| <b>Location of Construction:</b><br>51 ELIZABETH ST | <b>Owner Name:</b><br>FAETH ANGELA & STEVEN BUSH | <b>Owner Address:</b><br>51 ELIZABETH ST             | <b>Phone:</b> |
| <b>Lessee/Buyer's Name</b>                          | <b>Phone:</b>                                    | <b>Permit Type:</b><br>Change of Use Home Occupation | <b>Zone:</b>  |

| <b>Dept:</b> Building   | <b>Status:</b> Approved with Conditions | <b>Reviewer:</b> Jeanine Bourke | <b>Approval Date:</b> 11/15/2005                        |

2 STORAGE LOFT PLAN
1/4\"/>

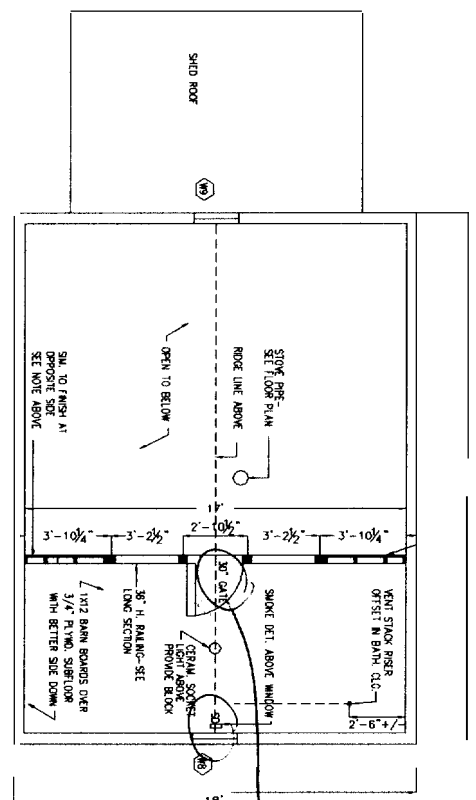
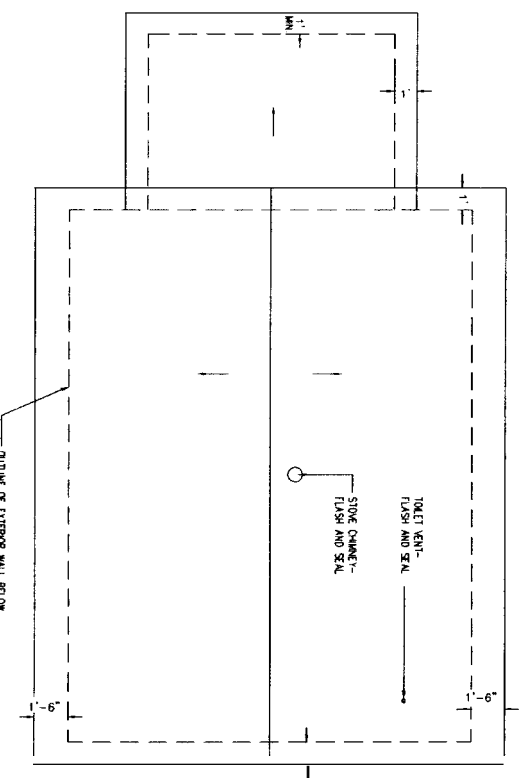
| 1) As discussed, the gate to the loft area is not required as it is to be used solely for storage and not to be a habitable space. Permanent stairs or ladders are NOT to be installed. |   |                                 |   |
